**945 Bank Street (Lansdowne 2.0 – Major Event Centre)** | Formal Review | Site Plan Control Application | City of Ottawa, Ottawa Sports and Entertainment Group, Brisbin Brook Beynon Architects, Fotenn Planning + Design, CSW, ERA Architects

**Panel Members in Attendance:** David Leinster | James Parakh | Emmanuelle van Rutten

DWG. TITLE
NORTH & SOUTH ELEVATIONS

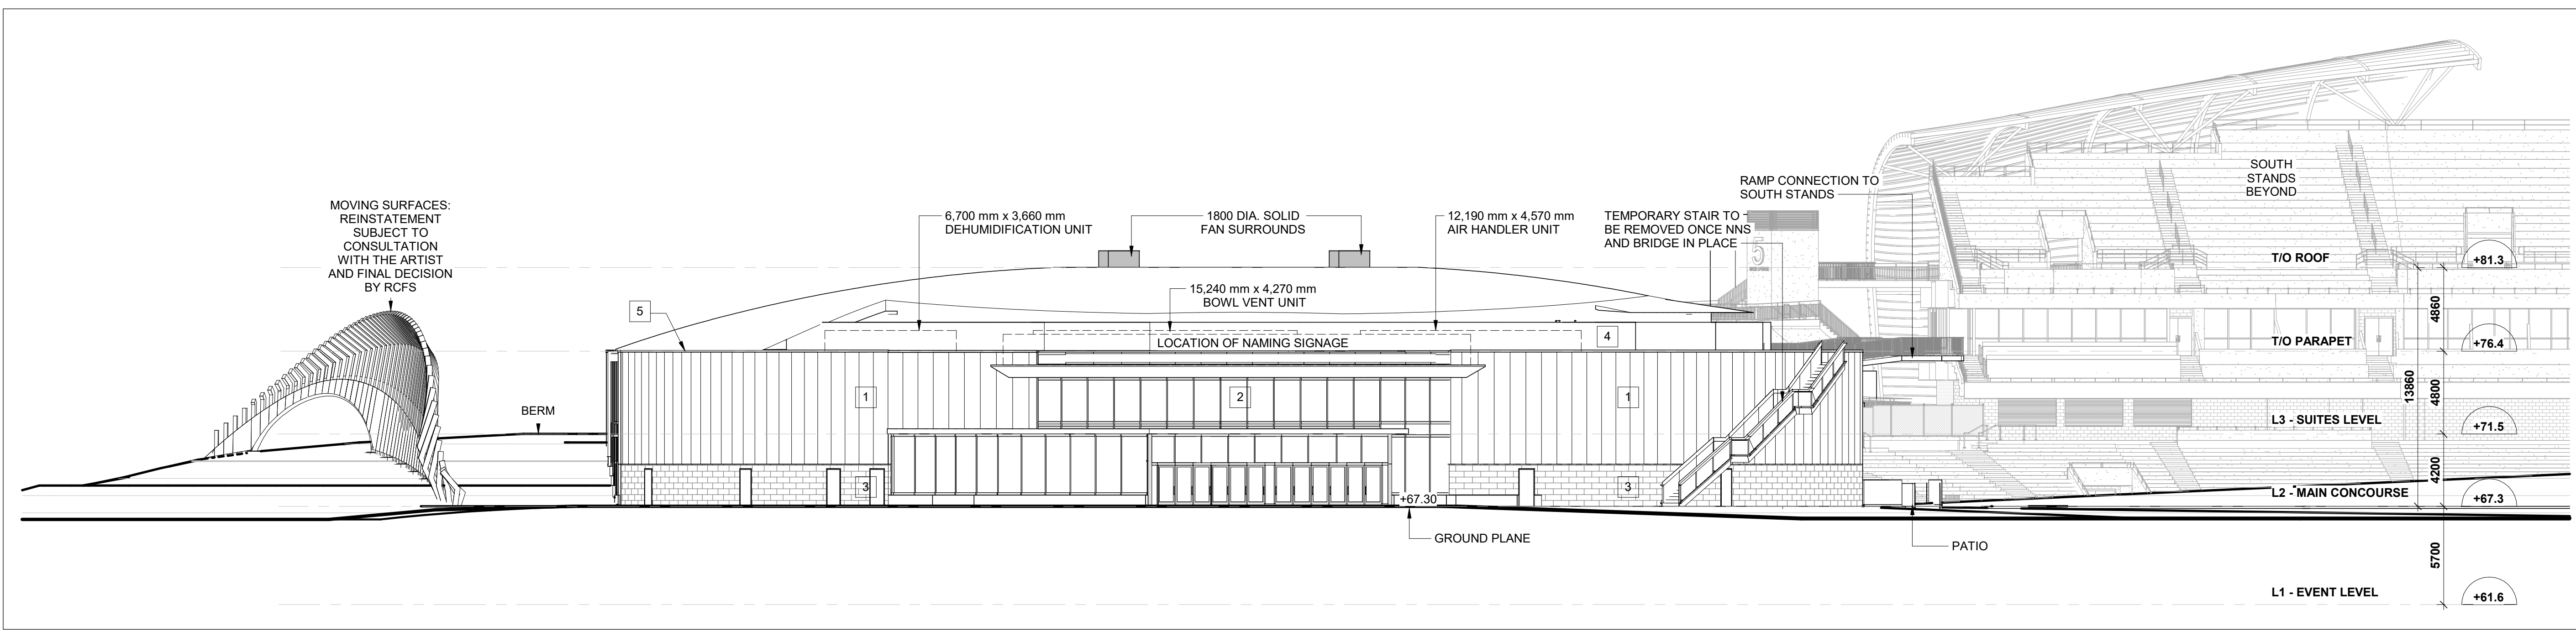
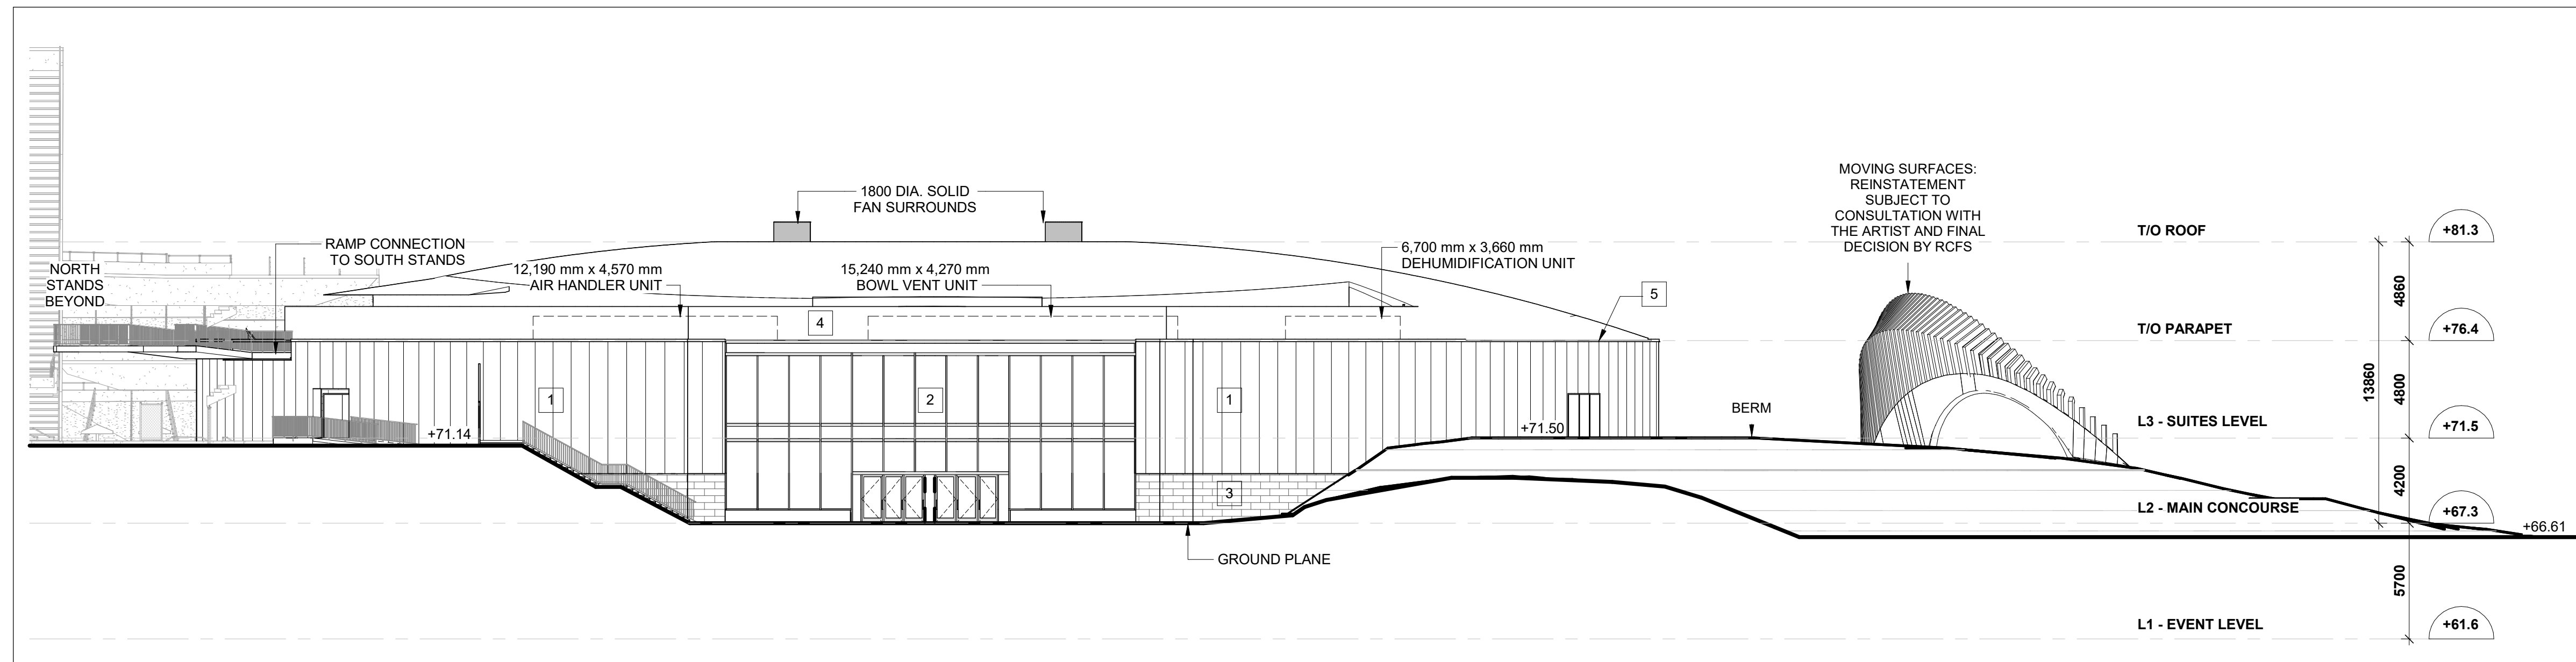
- The Panel recommends providing greater transparency in the Event Center façade, particularly with regard to improving visibility and interaction between the Event Center, the Great Lawn, and the Aberdeen Pavilion.

- The Panel suggests that the signage on the Event Centre must be subtle and context-appropriate, ensuring it does not interrupt sightlines or views, especially in relation to the dignity of both the UNESCO designated Rideau Canal and the Aberdeen Pavilion.

- The Panel recommends the Event Centre's façade should enhance transparency to create a stronger visual connection with the Great Lawn and the Aberdeen Pavilion. Entrances, such as washroom doors and other podium wall openings, require careful attention to articulation to avoid visual clutter and enhance the building's elegance.

- The Panel recommends ensuring the signage is discreetly integrated with the architectural elements, especially around key vistas and protected views from the Rideau Canal, in order to preserve the site's dignity and heritage.

2A RAISED PLANTER - WALL TYPES A, B, C
3.2 SCALE - 1:10

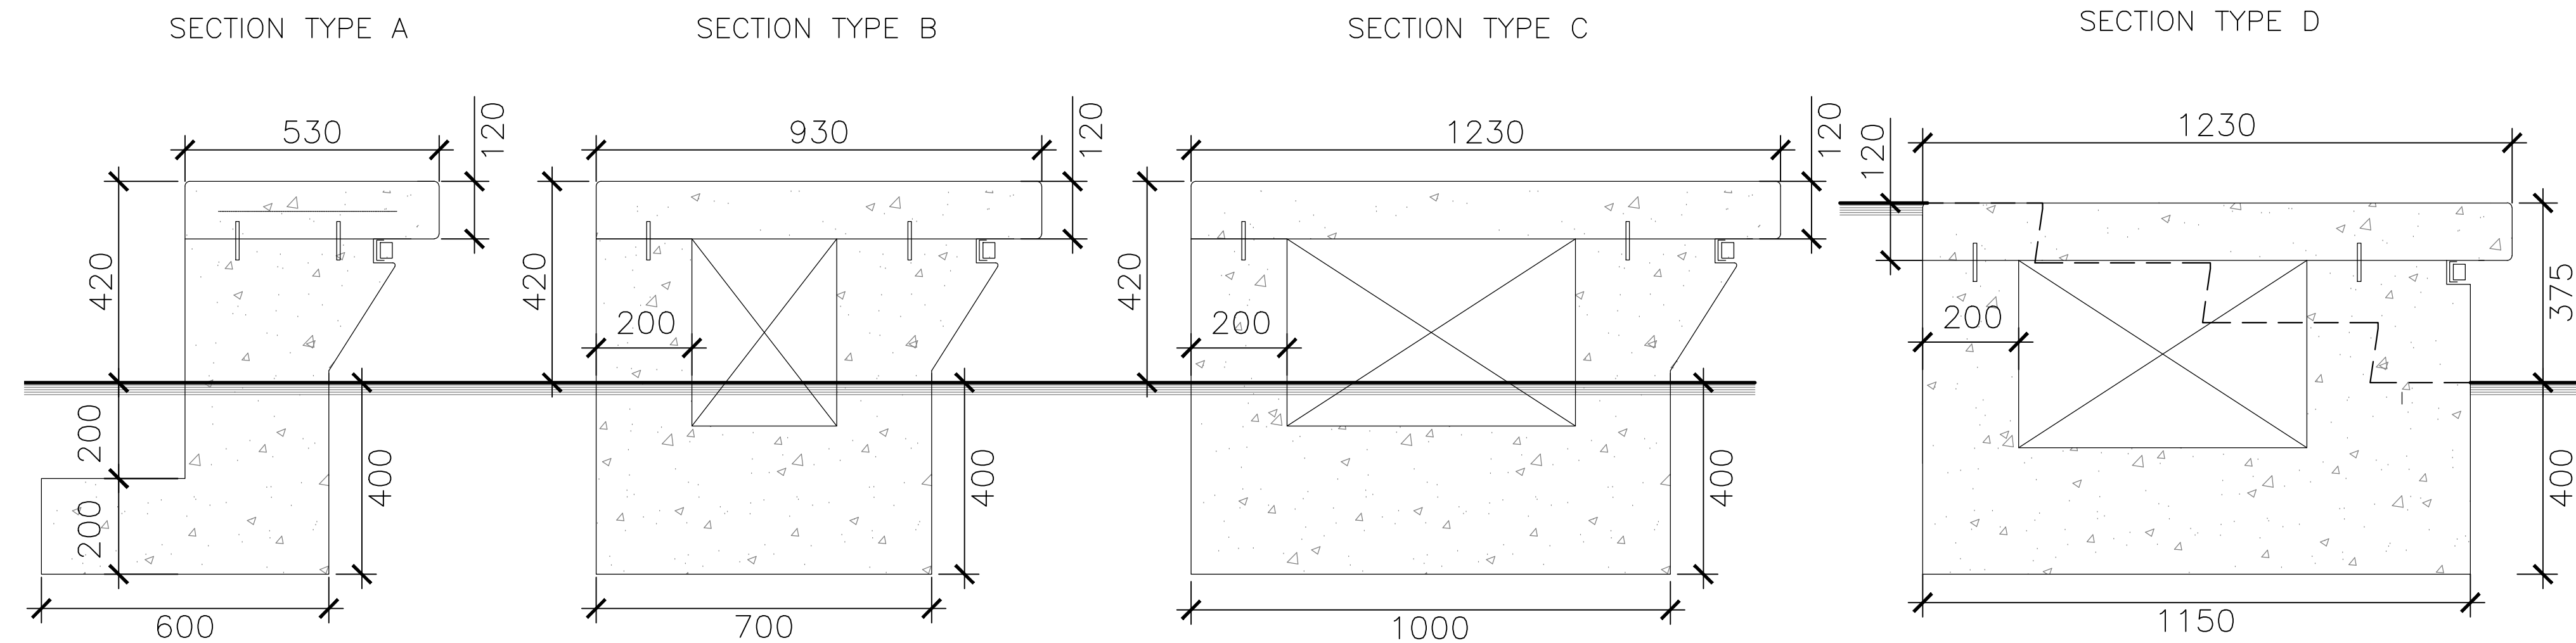
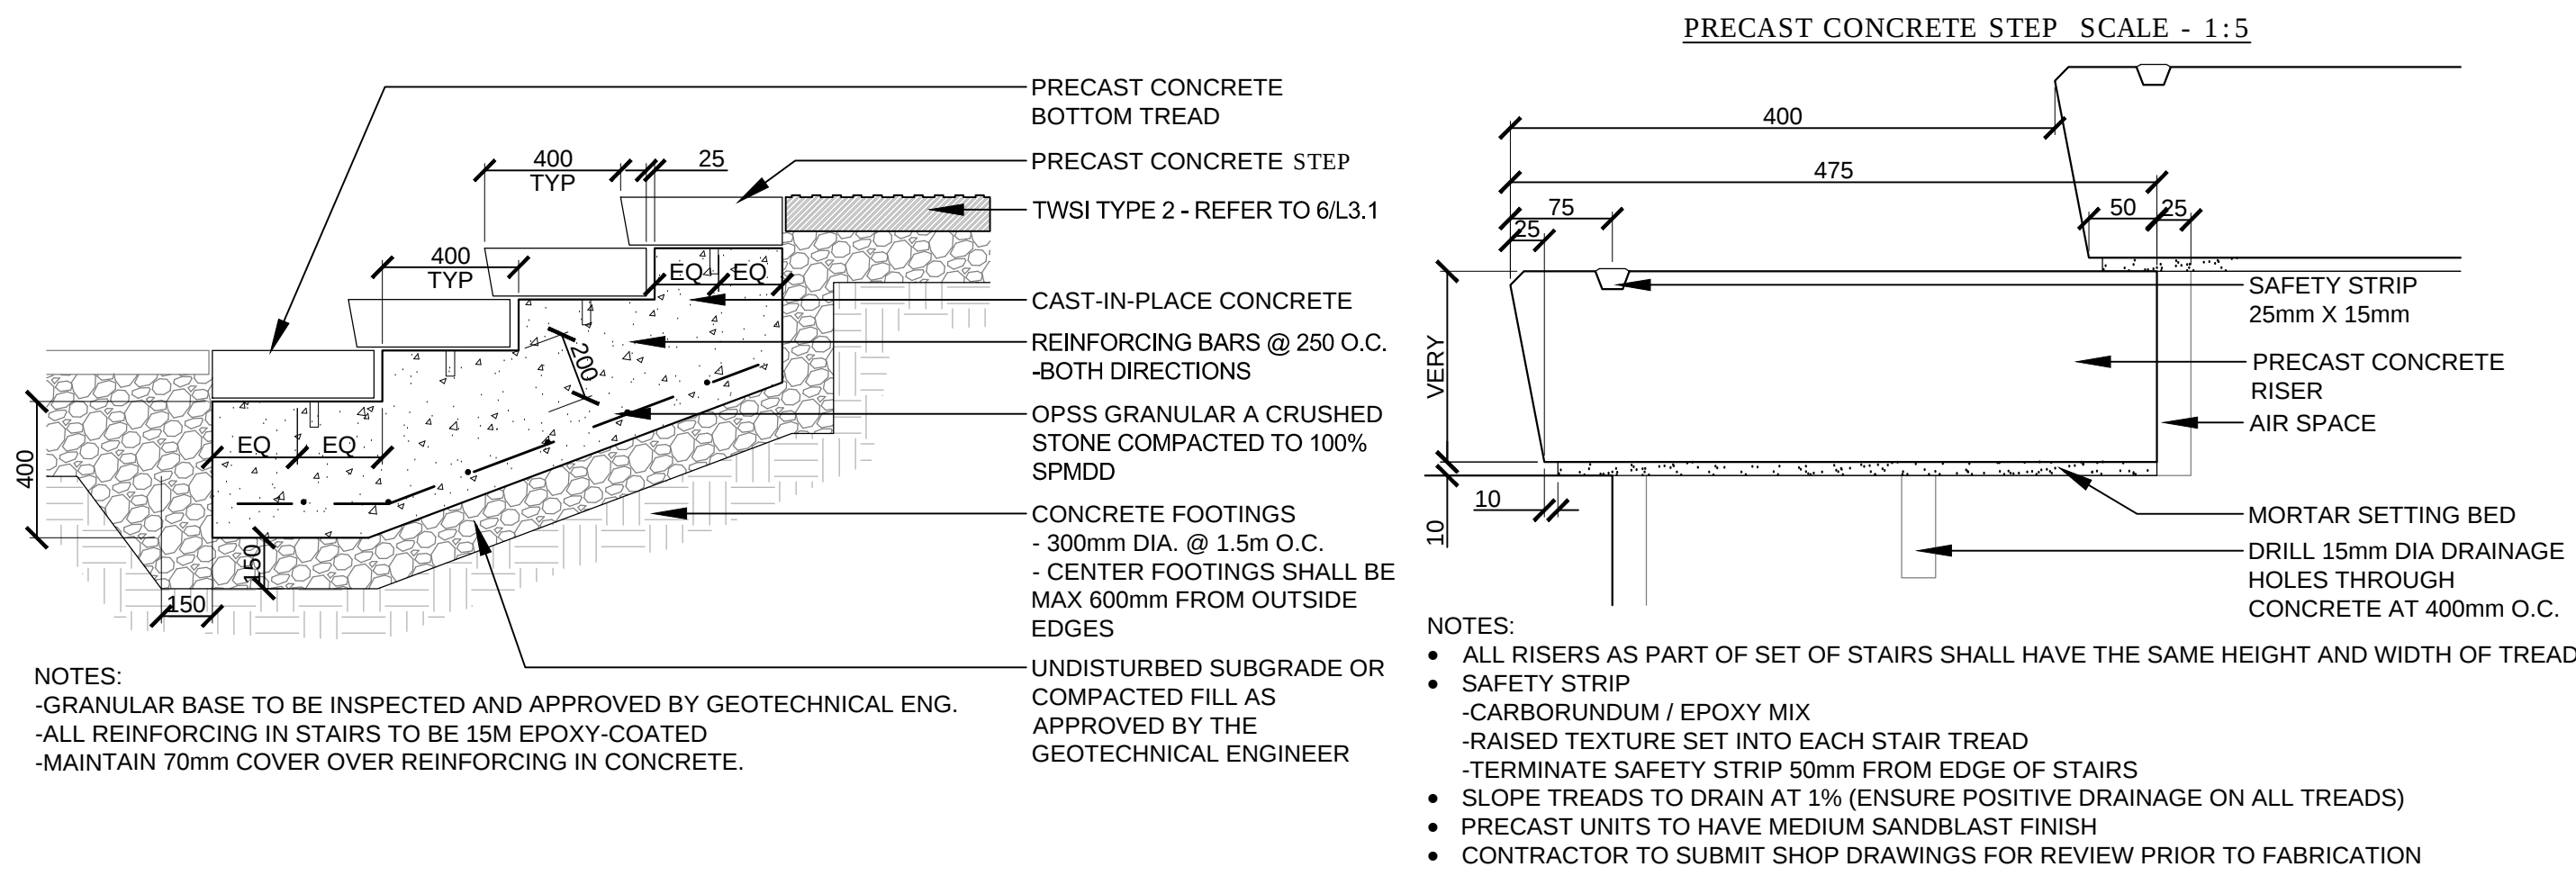
- The Panel recommends prioritizing and enhancing the pedestrian experience, especially along the north side of the event centre. The landscape design should clearly indicate the entrance area is shared space through its materiality, with discrete separation elements such as operable bollards rather than a raised planter. This will require further study and options analysis.
